Application No: EP/14/21/HH
Site Address: 38 The Roystons East Preston BN16 2TS
Description of works: Single storey side and rear extensions and conversion of roofspace to habitable use

Thank you for your internet representation made on 15th February 2021 which has been recorded as an objection with the comments as follows:

Drawing
Proposed first floor plan

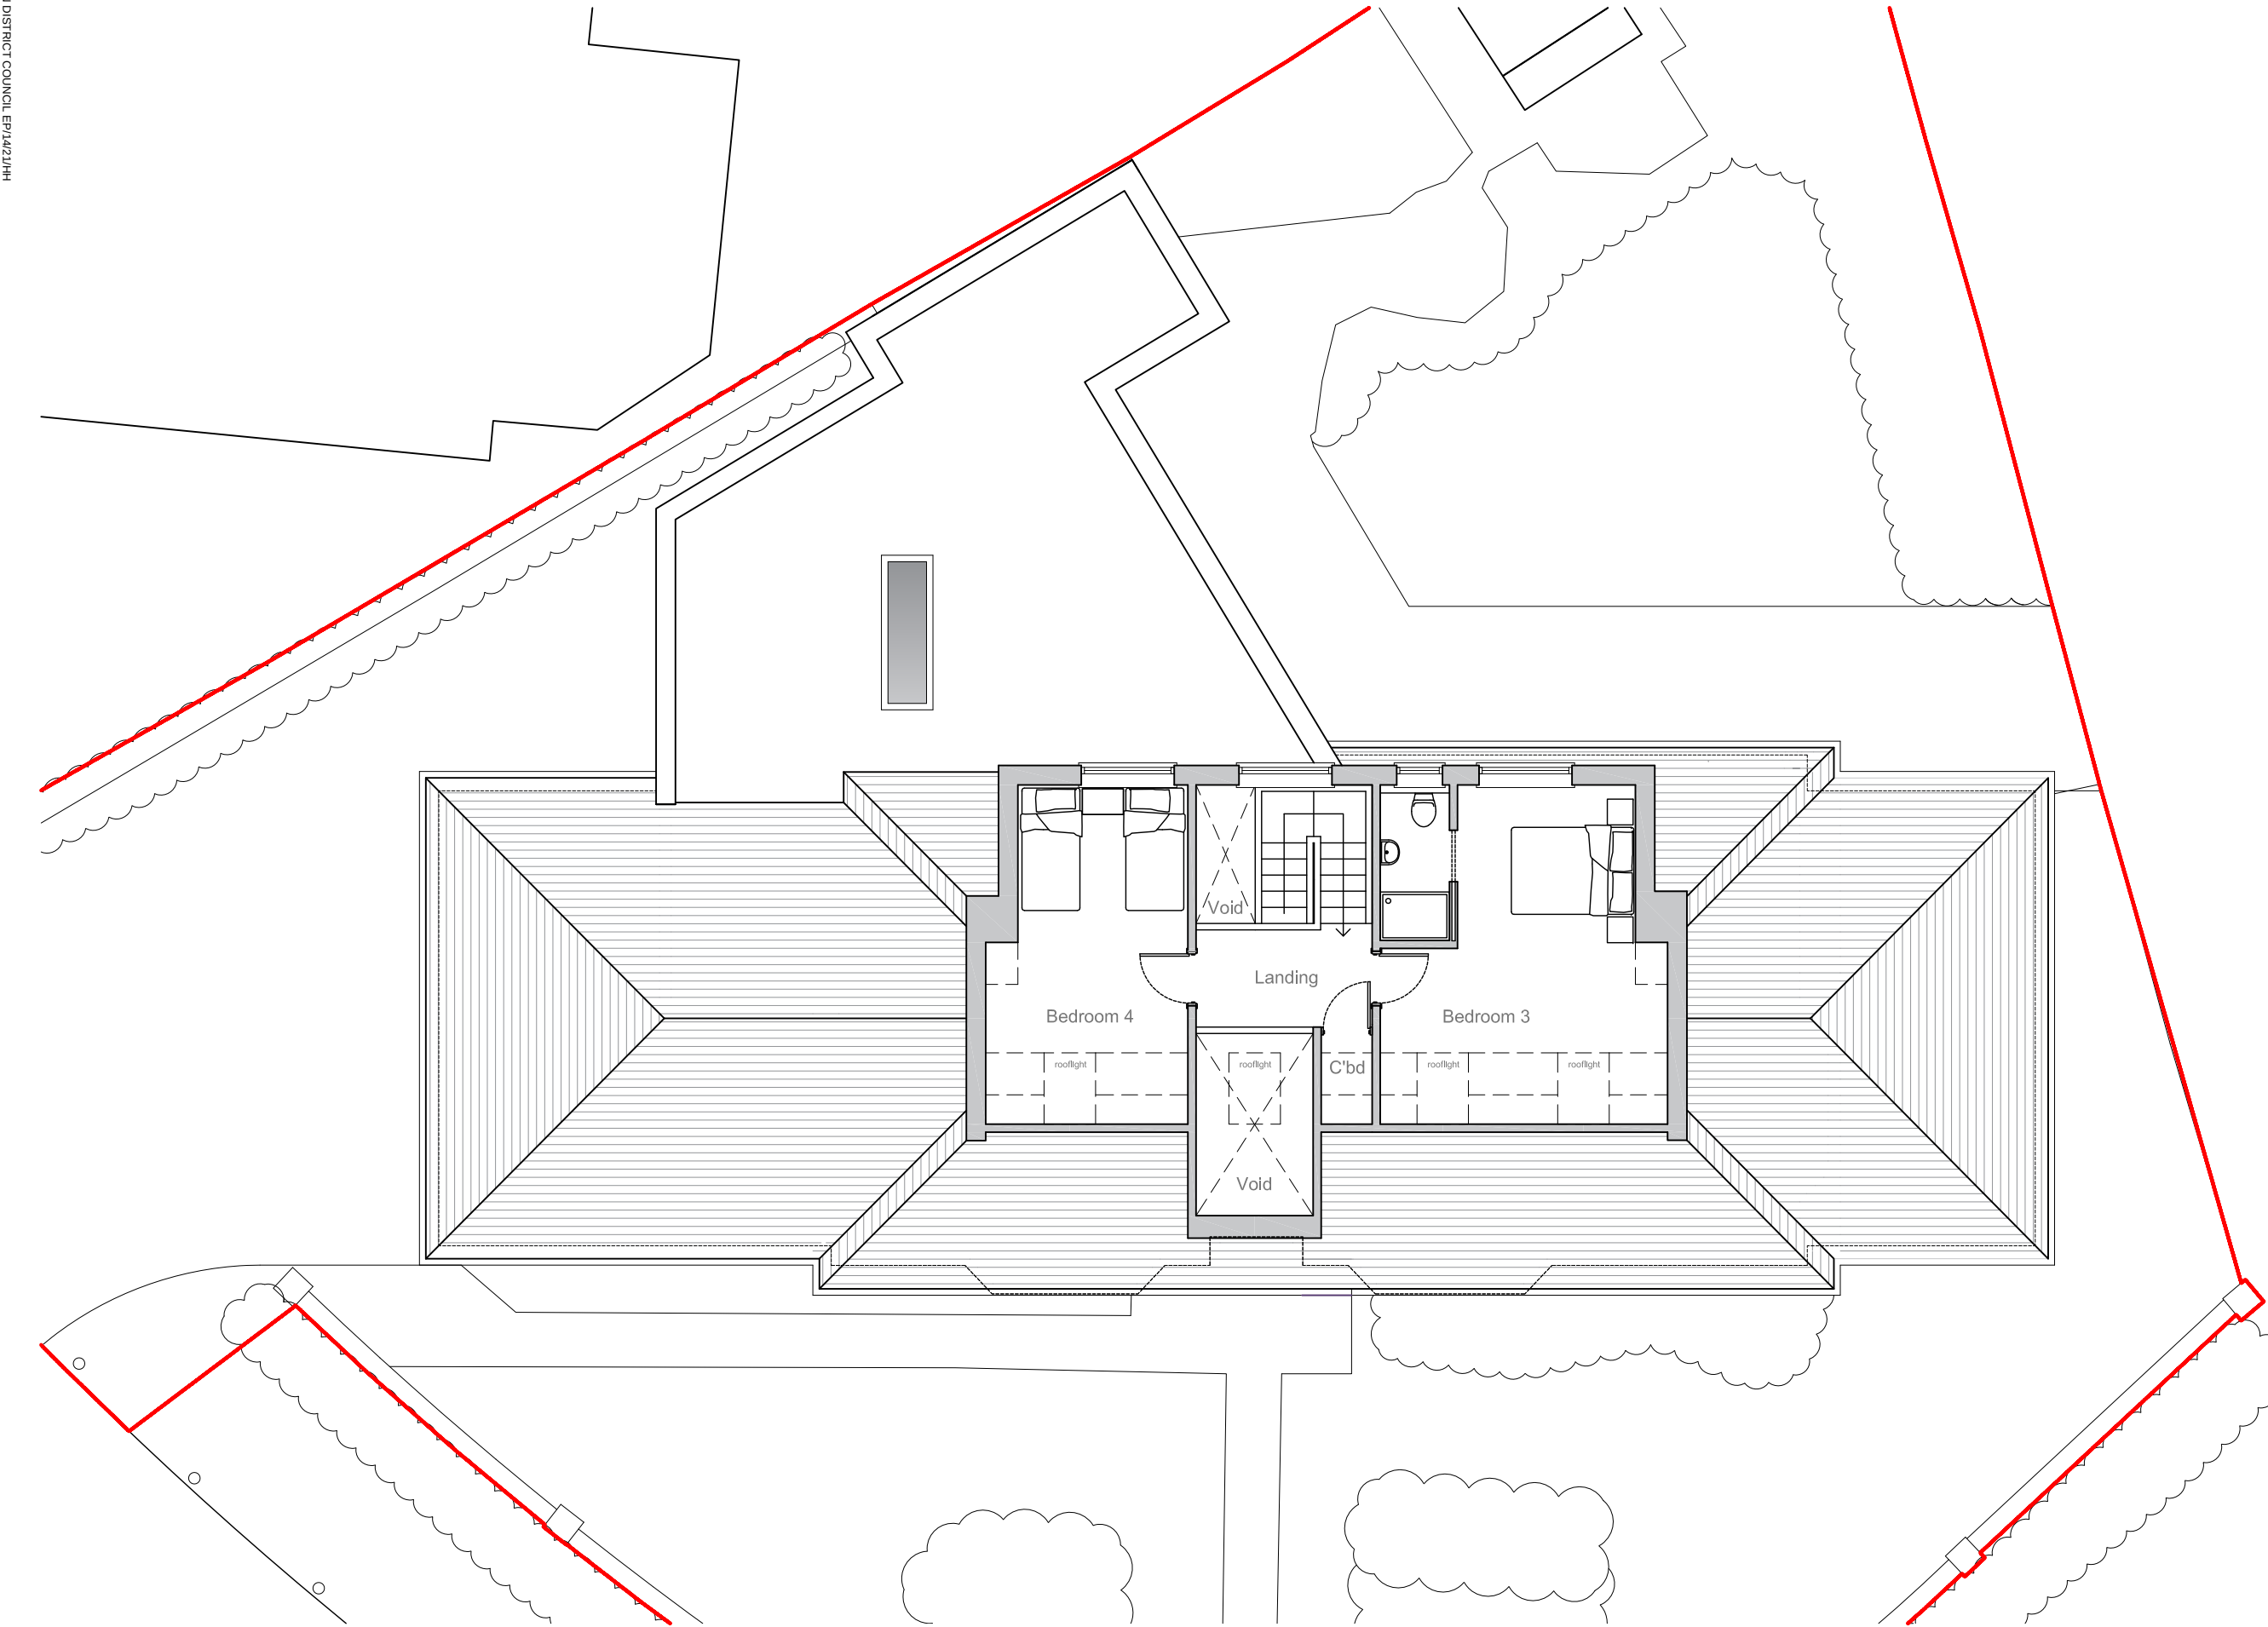
I seriously object to the size of the roof extension. It will overlook the whole of my back garden, our kitchen and our little sun room.
These windows will invade and destroy our privacy.
